DRB Application No.: 05DRB-01211 (FP)
Project Name: SUNDORO SOUTH UNIT 5
Agent: Mark Goodwin & Associates

CITY OF ALBUQUERQUE
PLANNING DEPARTMENT
AUGUST 3, 2005
DRB Comments

RE: Sundoro South Unit 5/final plat

Limits of FEMA Floodplain  
 Until such time that the LOMR is issued by FEMA to remove the  
 floodplain, this area and any future lots that develop in this area,  
 SIMPLY AS PUBLIC  
 RIGHT-OF-WAY

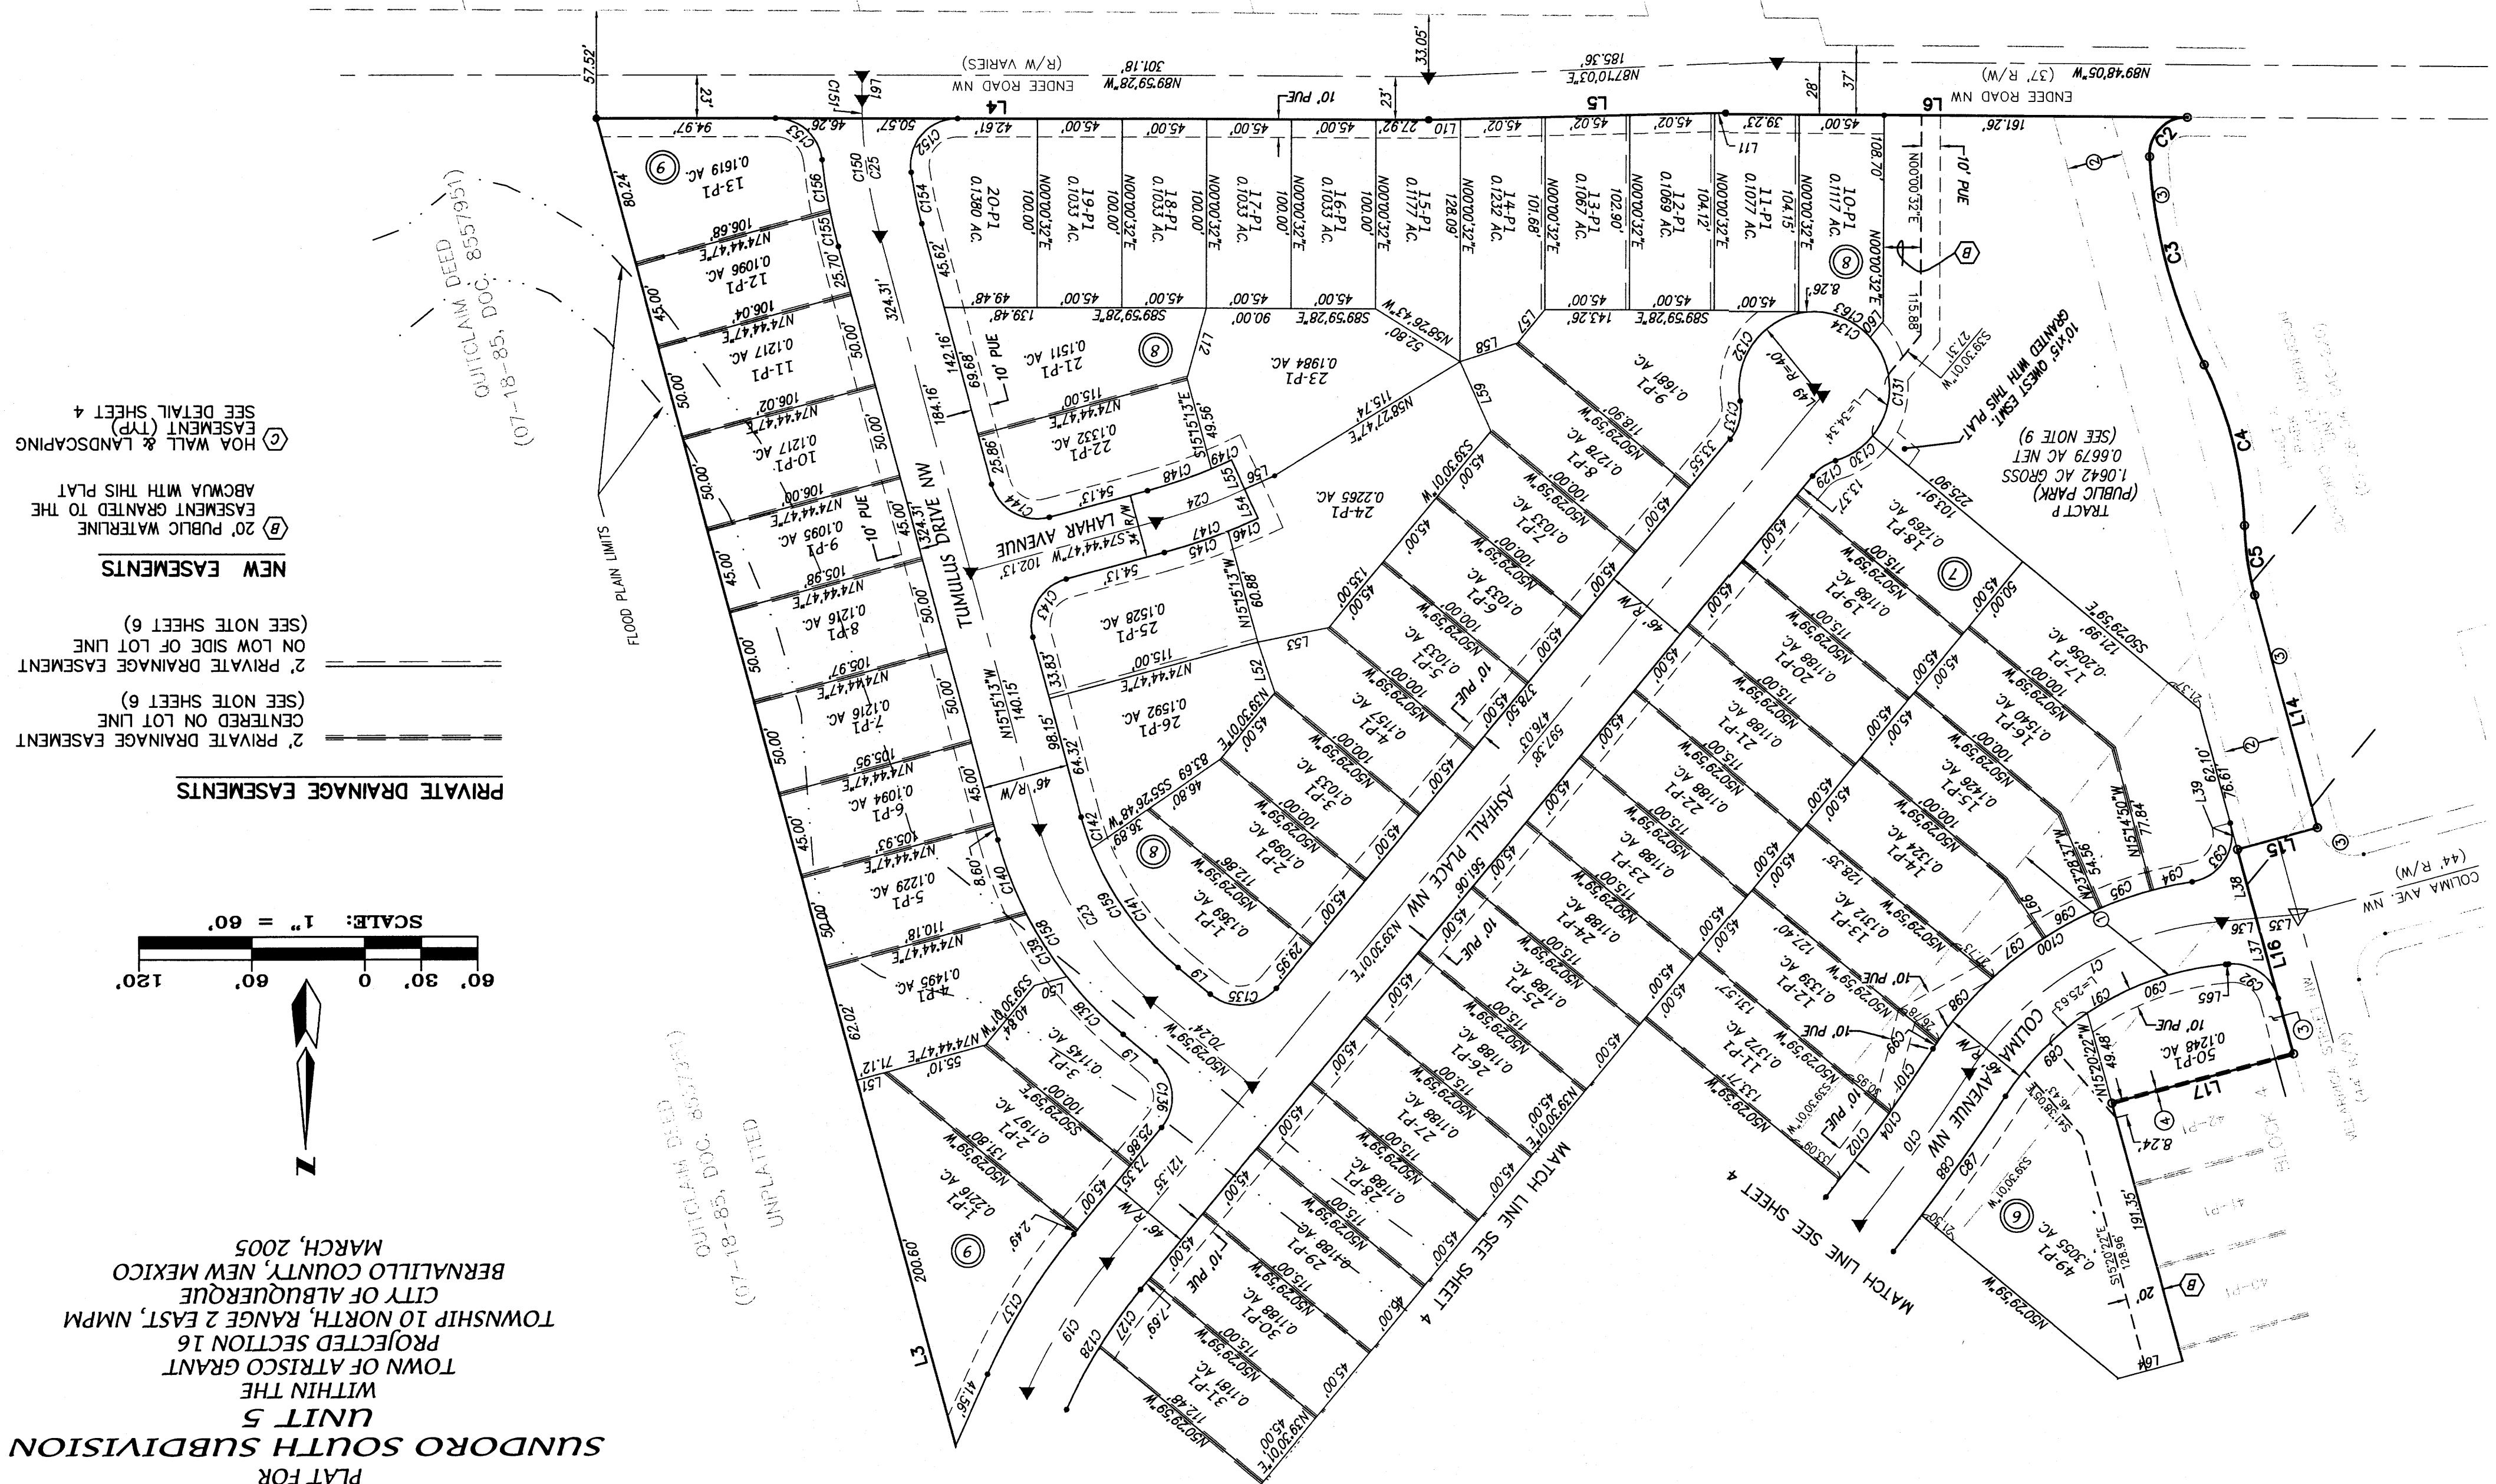
✓ Are the perimeter walls approved for this Unit?

Are there any changes since preliminary plat approval?

Have the 2 conditions of final plat been met?

✓ • Tracts O & Q were to be conveyed to the adjacent subdivision for platting.

• Right of way or easements were to be provided for Kipuka

Rec'd
leaded
Plat

AGIS dxf is approved.

Planning must record this plat. Planning will take delegation.
